POST EPC MEMORANDUM

RE: **SP-2025-00066** – Site Plan– EPC

The Agent, Community Design Solutions, for Discount Towing & Collision, has worked with Staff to fulfill post EPC requirements to meet Conditions of Approval 1-6, for the approval of Site Plan-EPC, for all or a portion of Lots 1, 2 & 8-13 Amended & Supplemental Replat Blocks A-B & C Monkbridge Addition, located on the northeast corner of 2nd St NW and Headingly Ave. NW (the “subject site”). Approximately 2.0711 acres. See EPC Notice of Decision (NOD) dated October 16, 2025.

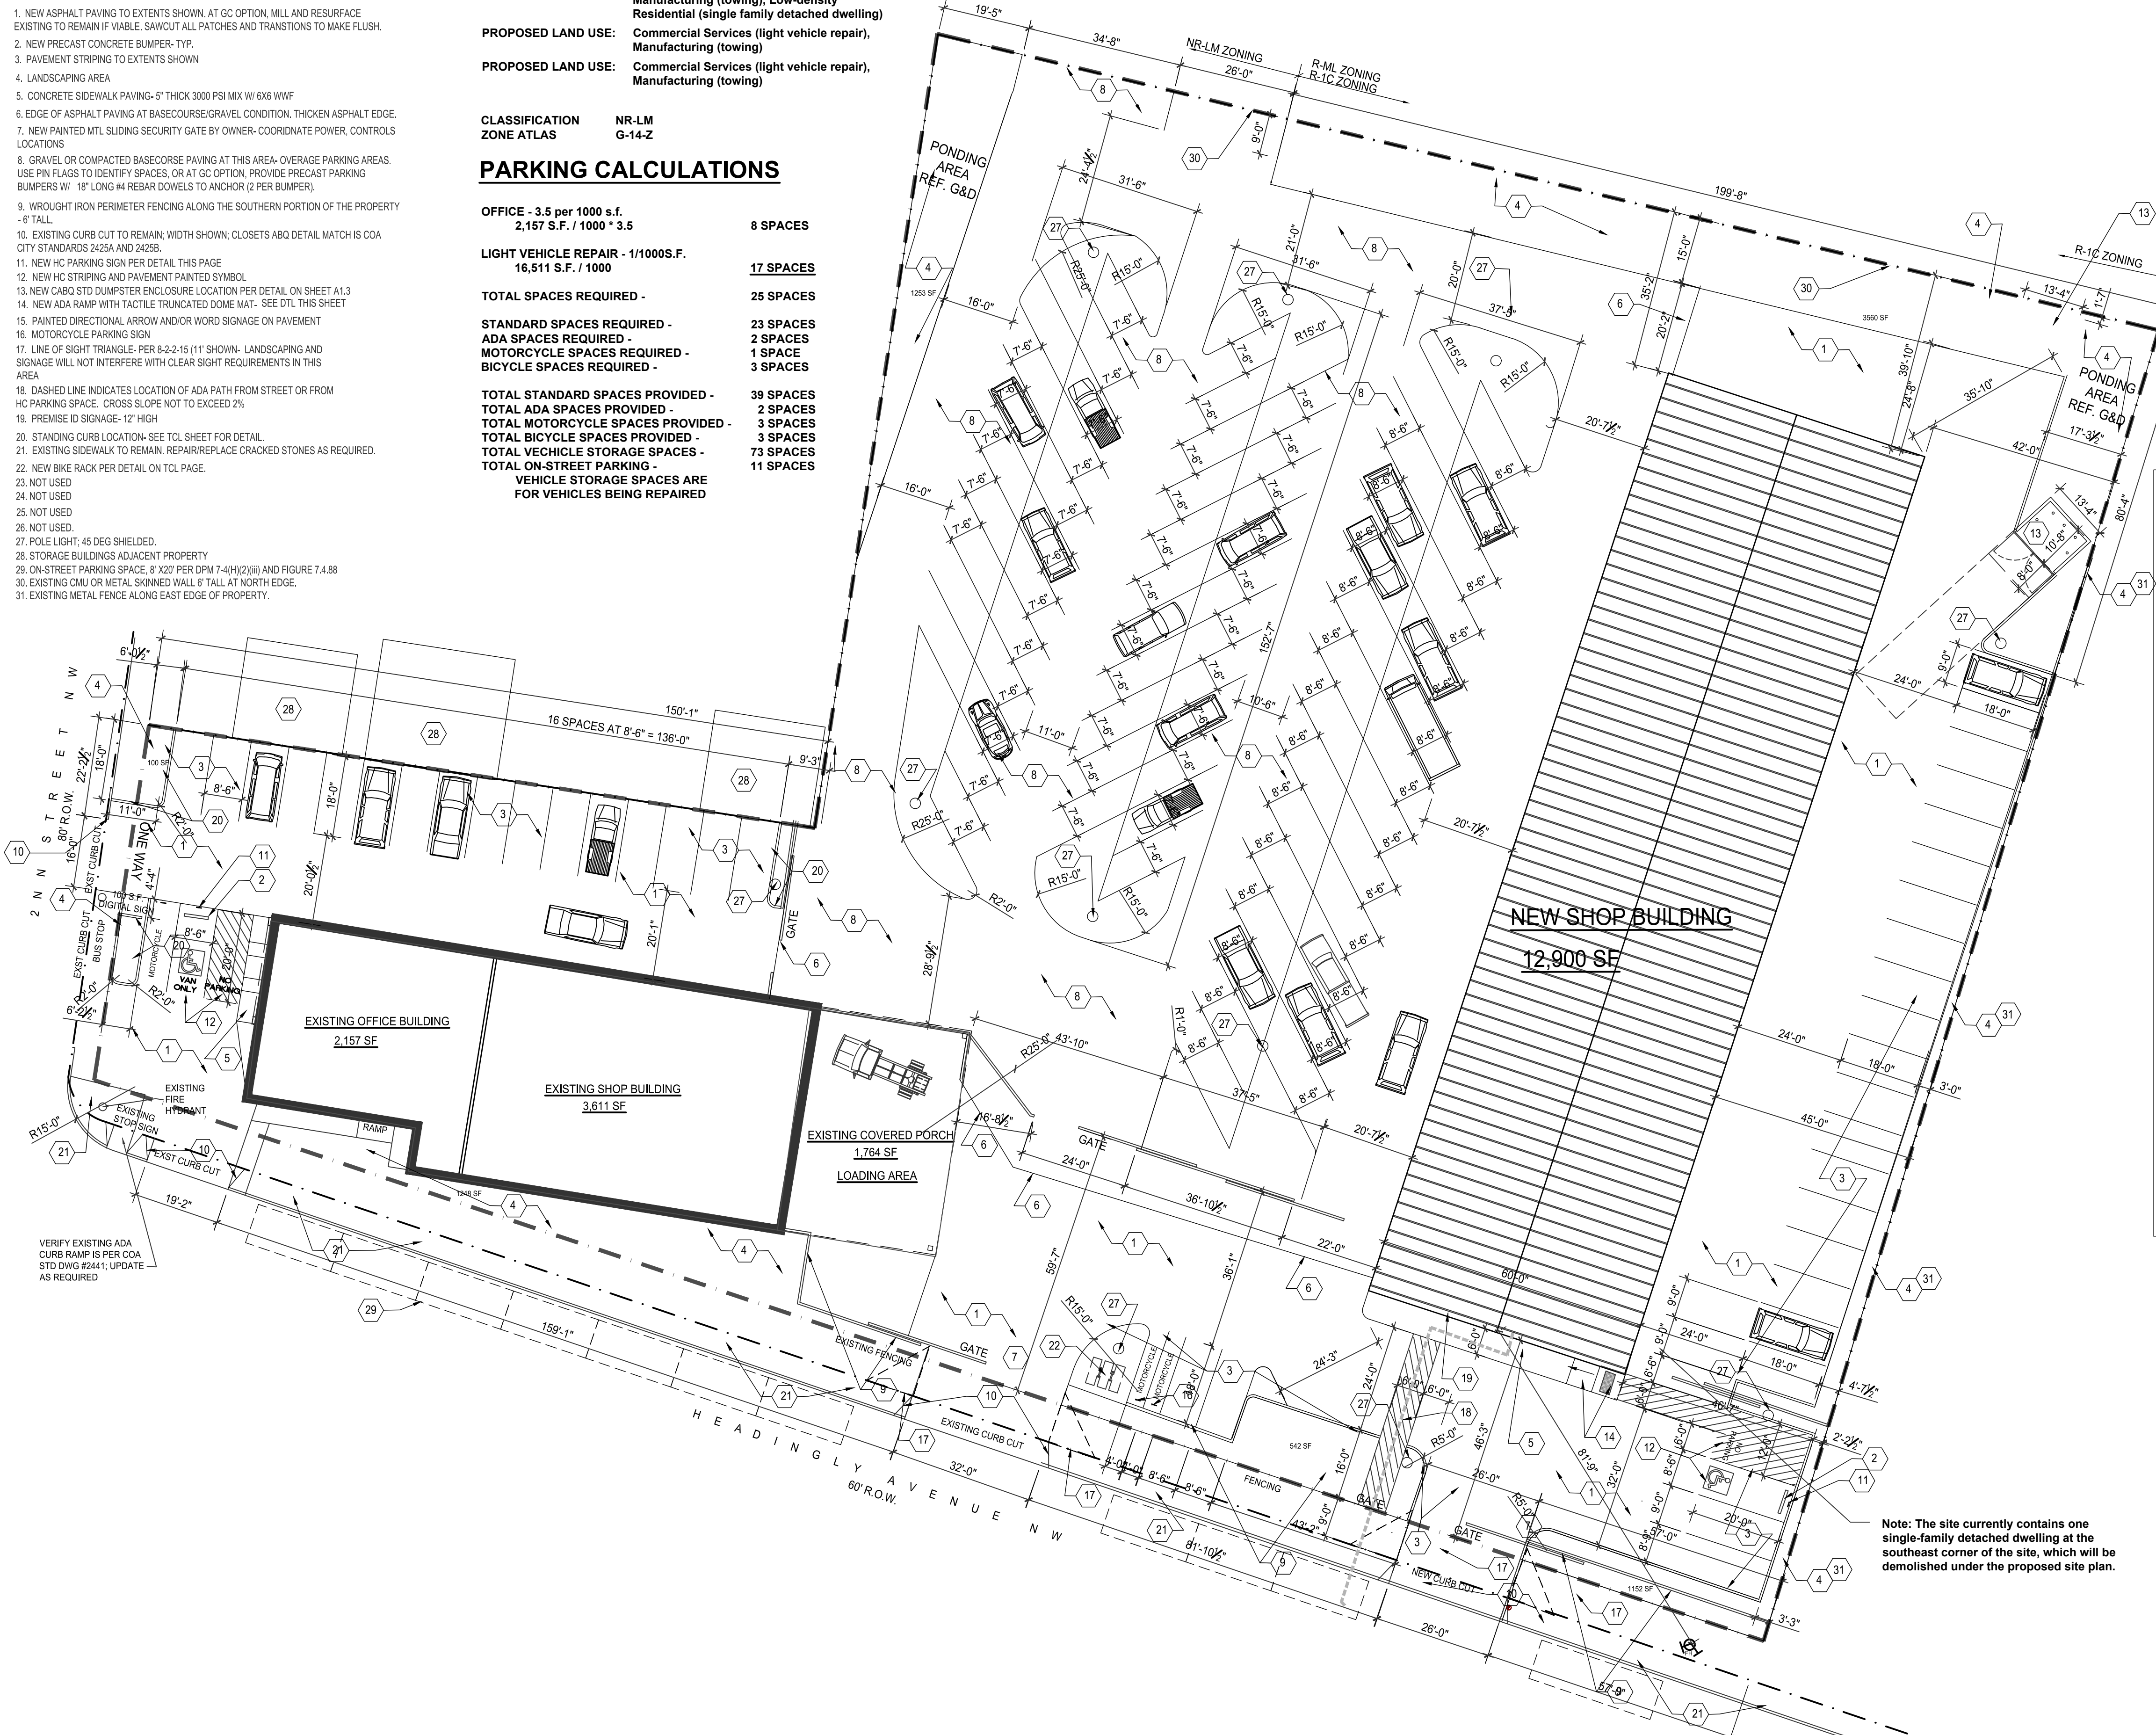
- A. The site plan shall include a keyed note indicating the type and height of the existing wall on northern boundary of site.

- B. Keyed note #9 shall be updated to state "wrought iron perimeter fencing along the southern portion of the property - 6' tall.

- C. A keyed note shall be provided indicating fence types around the east and northern perimeter of the property.

- A. Parking spaces along the northern property line shall be removed or reconfigured to comply with the IDO.

Condition 3-A has been met, see keyed note (30)

Condition 3-B has been met, see revised keyed note (9)

Condition 3-C has been met, see keyed note (31)

Condition 4-A has been met, Parking spaces have been removed and replaced with a landscape buffer which provides the required 15ft minimum separation between parking areas and neighboring residential properties, in this case, zoned R-1.

### Landscape Plan

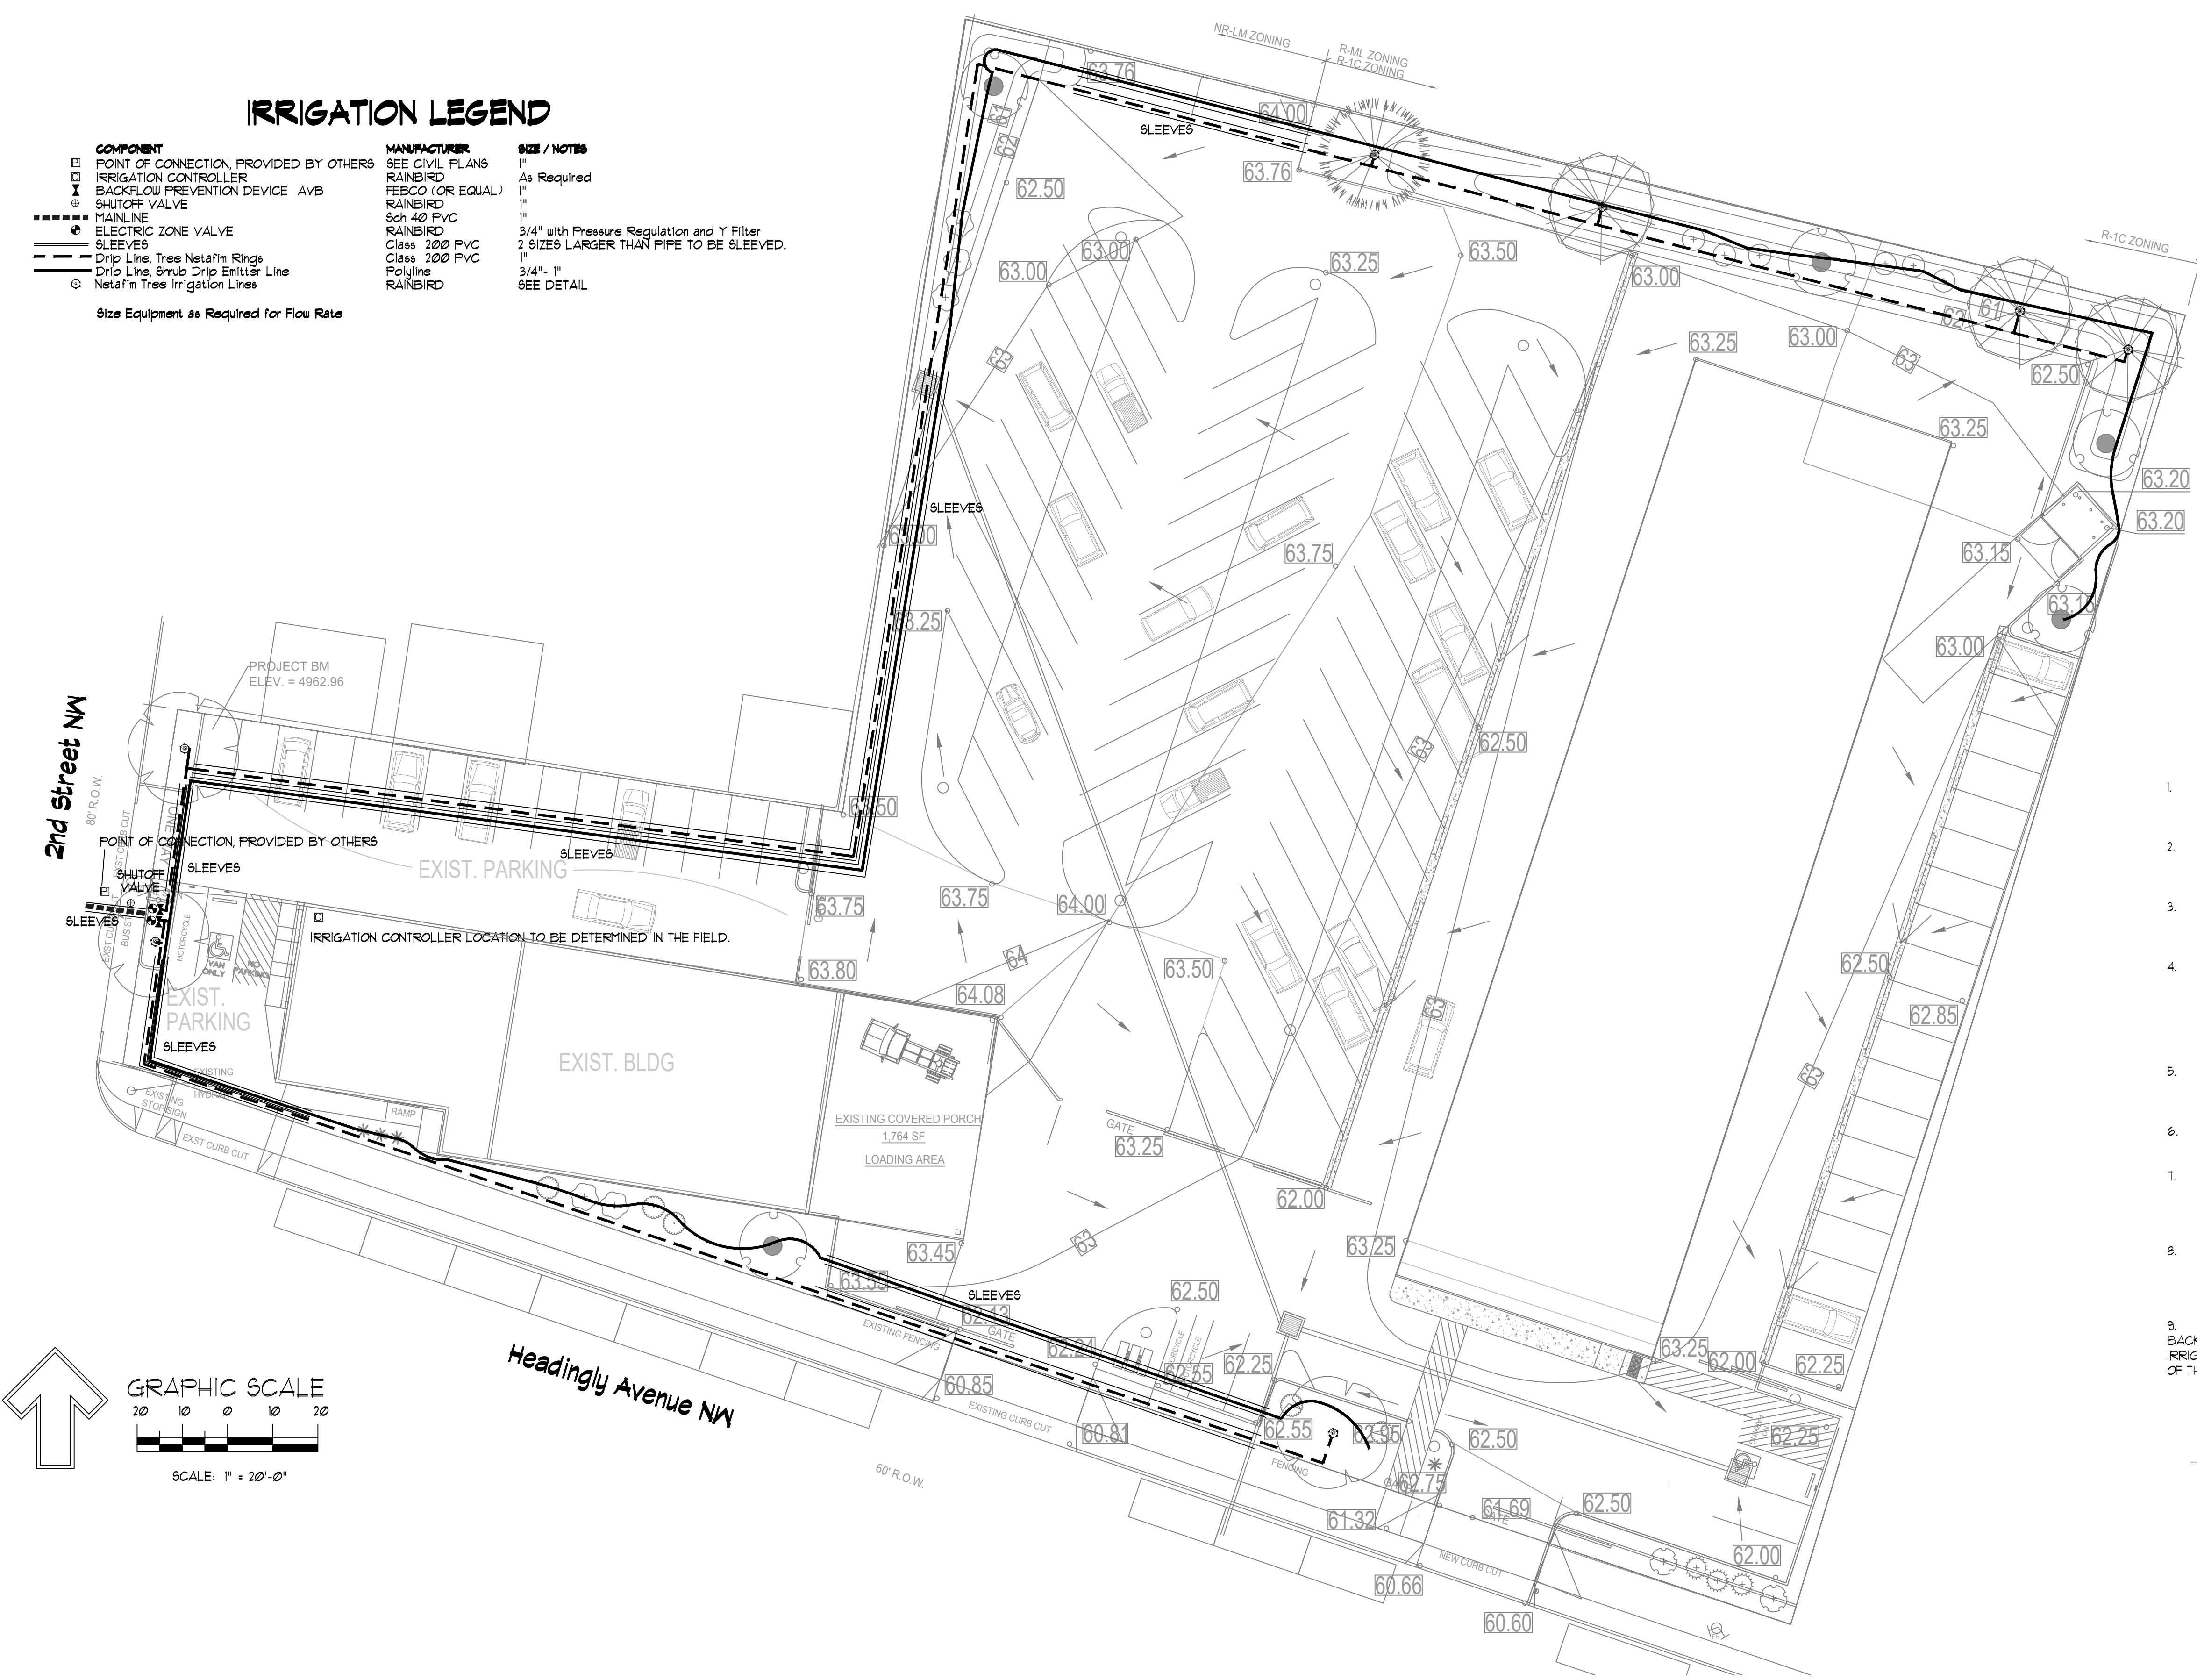
5. The Landscape Plan shall comply with neighborhood edge requirements in IDO §14-16-5-69E). The site plan shall be updated to reflect EITHER of the following options:

- A. One tree at least 8ft high at the time of planting shall be provided for every 15ft along the existing 6ft opaque wall along the northern boundary of the site (abutting residential properties) pursuant to IDO [14-16-5-6\(E\)\(2\)\(a\)1.](#)

- B. A 15ft landscaped buffer area is required pursuant to IDO §[14-16-5-9\(D\)\(1\)\(b\).](#) Parking areas shall be separated from any abutting Protected Lot by a minimum of 15 feet, and edge buffer requirements in Subsection 14-16-5-6(E) apply. See also Table 5-6-4: Edge Buffer.

- A. Street trees are required along 2nd Street NW. within 20' from back of curb and spaced at 25' on center per IDO 5-6(D)(1). Please provide measurements and calculations showing street trees within these parameters for DFT staff.

- B. New Mexico Olive, Desert Willow, Crape Myrtle and Vitex are not acceptable for use as street trees as they do not meet the intent of street trees to provide shade and coolness in summer months.

Condition 5-A has been partially met by providing trees at least 8ft high and 30ft apart.

Condition 5-B HAS been met, Parking spaces have been removed and replaced with a landscape buffer which provides the required 15ft minimum separation between parking areas and neighboring residential properties per edge buffer requirements in Subsection 14-16-5-6(E).

Condition 6-A has been met or is agreed to by the applicant to plant the (2) Gamble Oak trees along 2nd street to be at least 25ft apart on center per IDO 5-6(D)(1) and noted in 'Street Tree Notes' on the Landscape Plan.

Condition 6-B has been met. The applicant has modified the site plan to include street trees that are in compliance with Urban Forestry along 2nd Street.
